El Paso County
Development Services Department
2880 International Circle, Suite 110
Colorado Springs, CO 80910-3127
Attn: Nina Ruiz

June 13, 2017

**RE: Woodmen Hills Metropolitan District
Regional Water Reclamation Facility
Administrative Plot Plan – Drainage Letter**

**WOODMEN HILLS METROPOLITAN DISTRICT
 REGIONAL WATER RECLAMATION FACILITY
 DRAINAGE MAP**

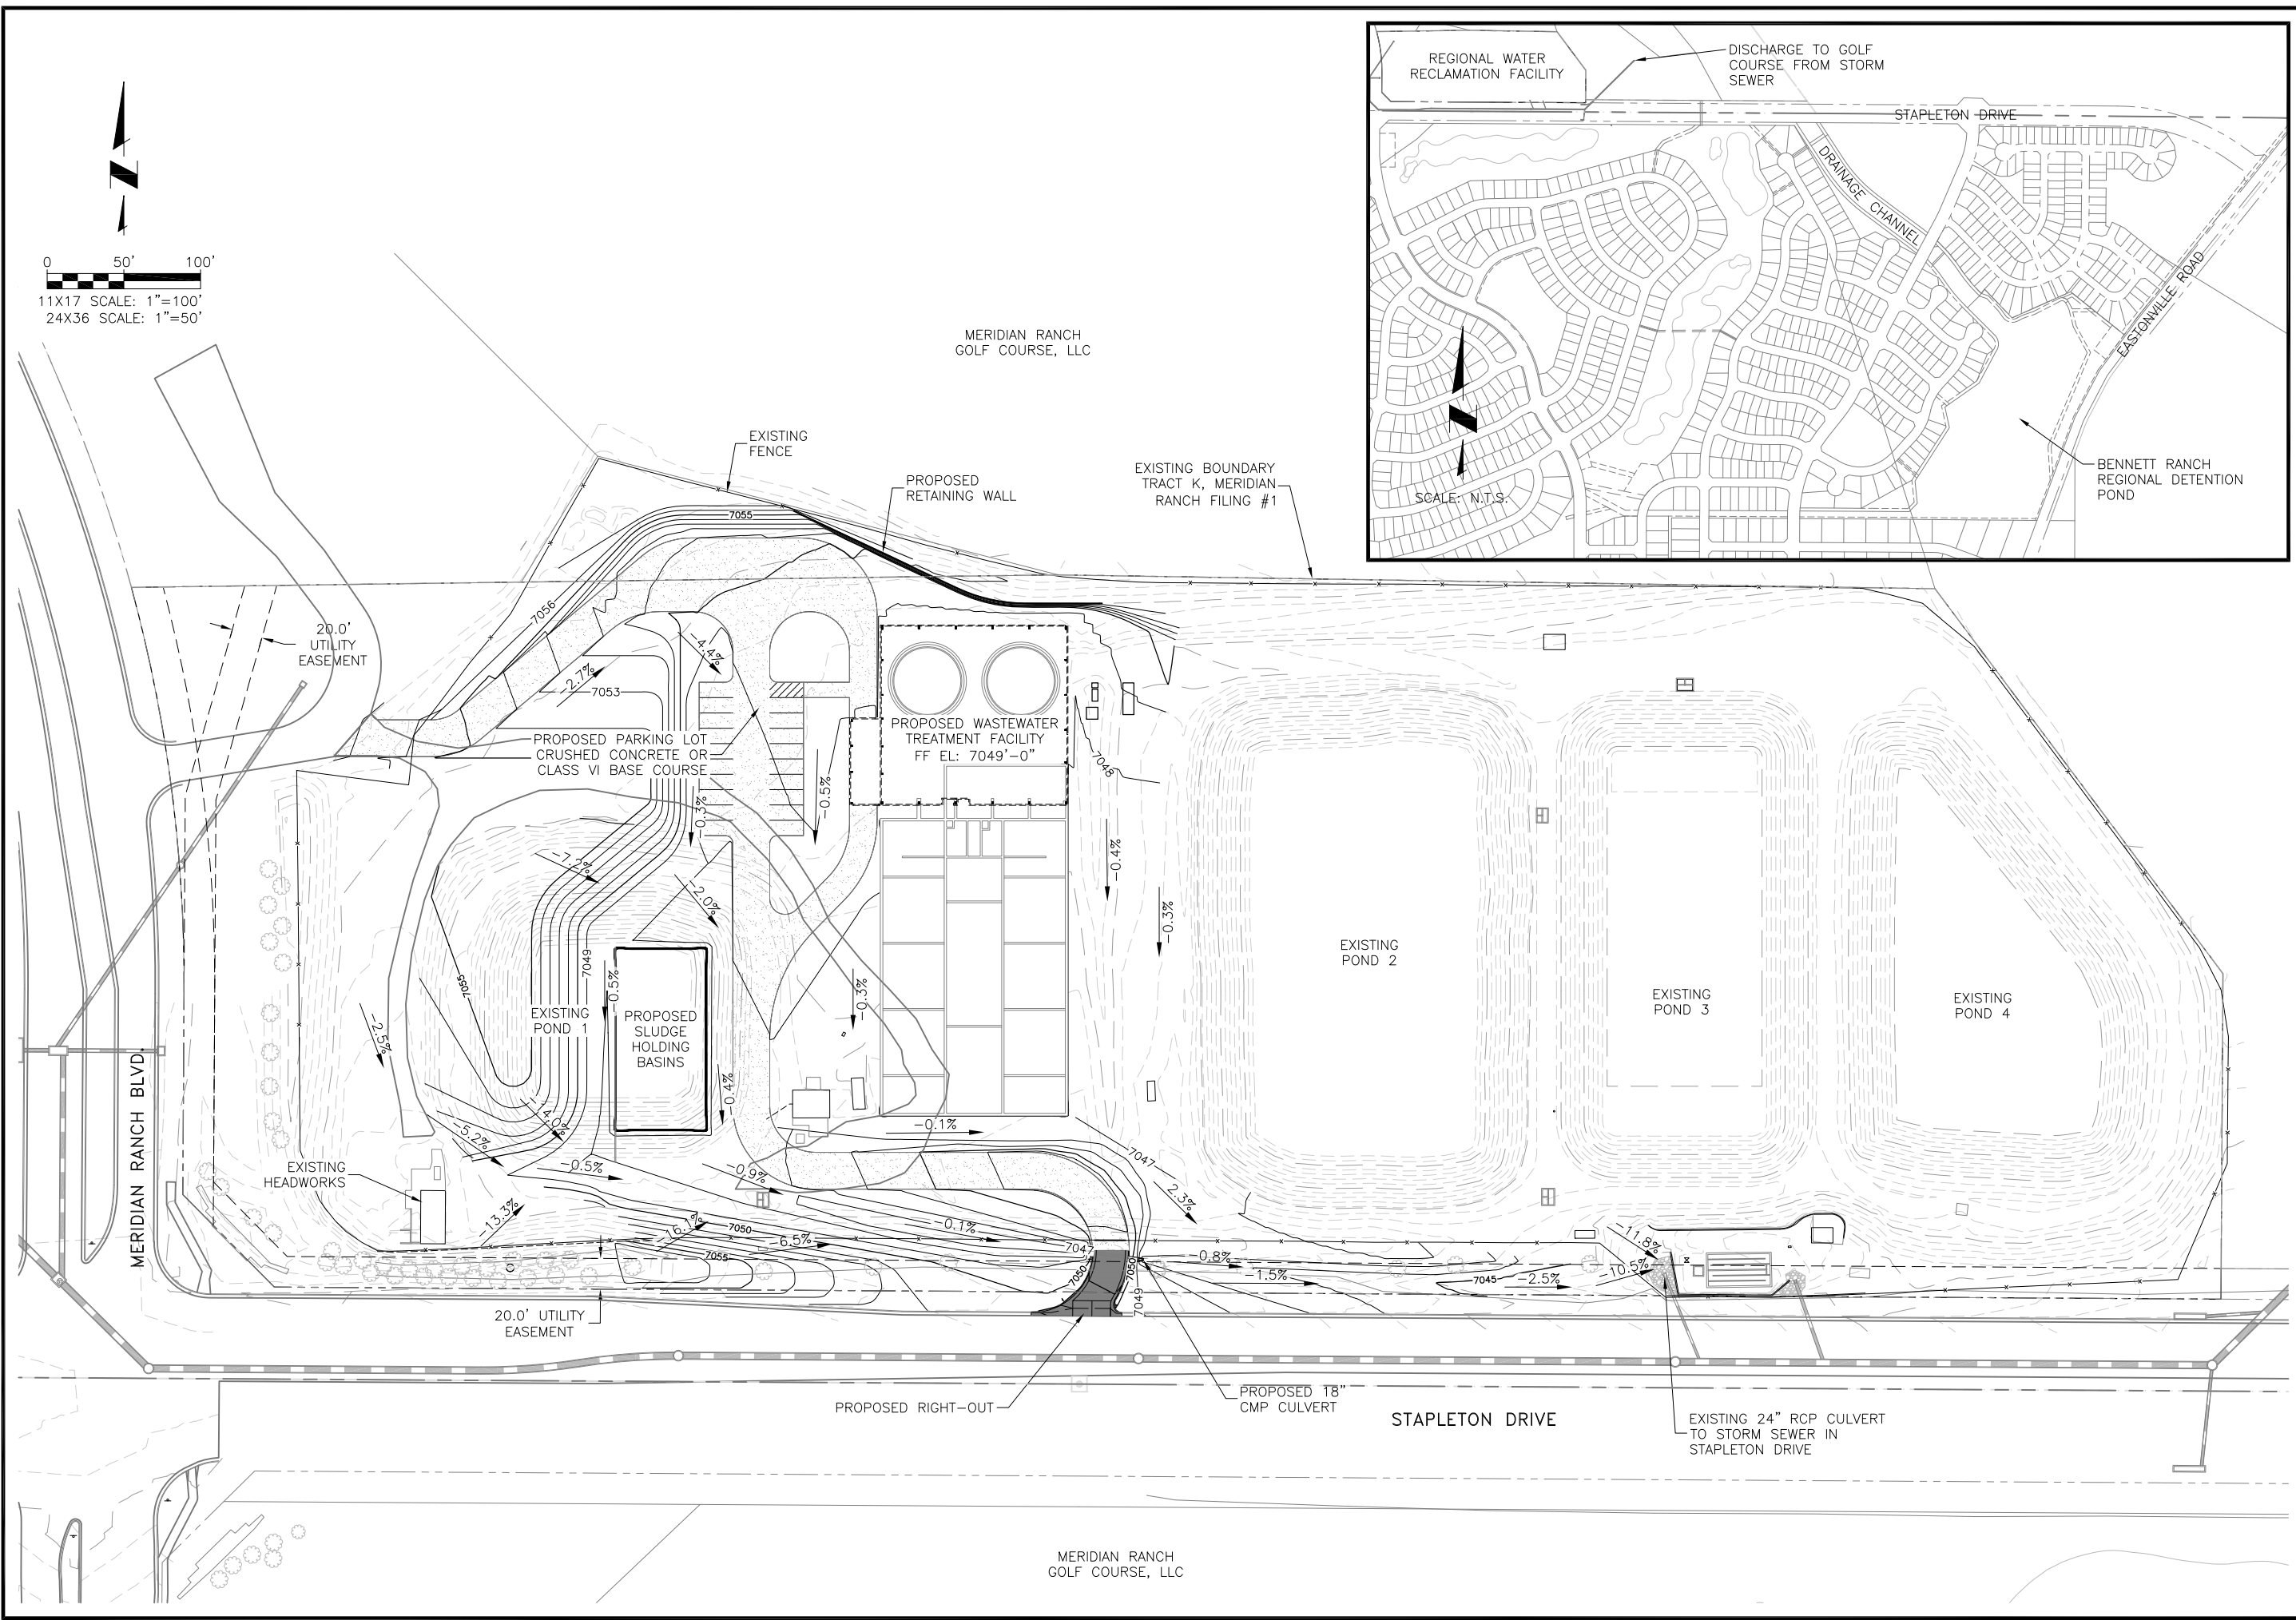
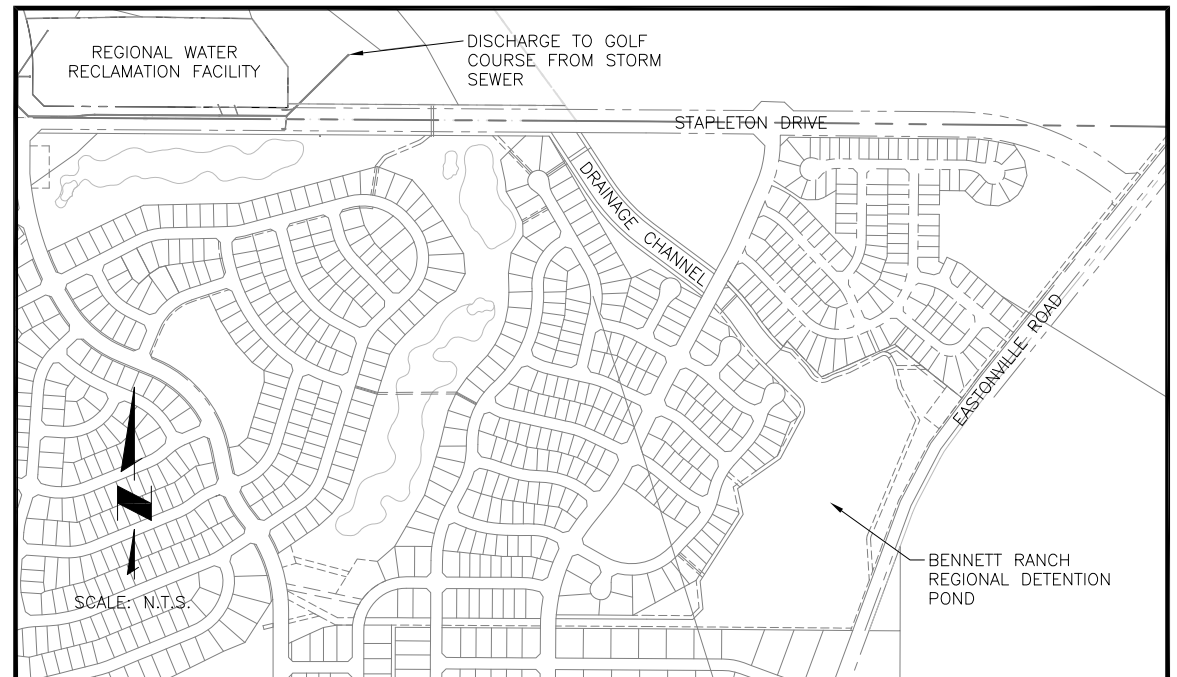
Per the early assistance meeting, submit a drainage letter with analysis and calculation to determine the extent of wq/detention required on-site. Must also include existing and proposed drainage maps.
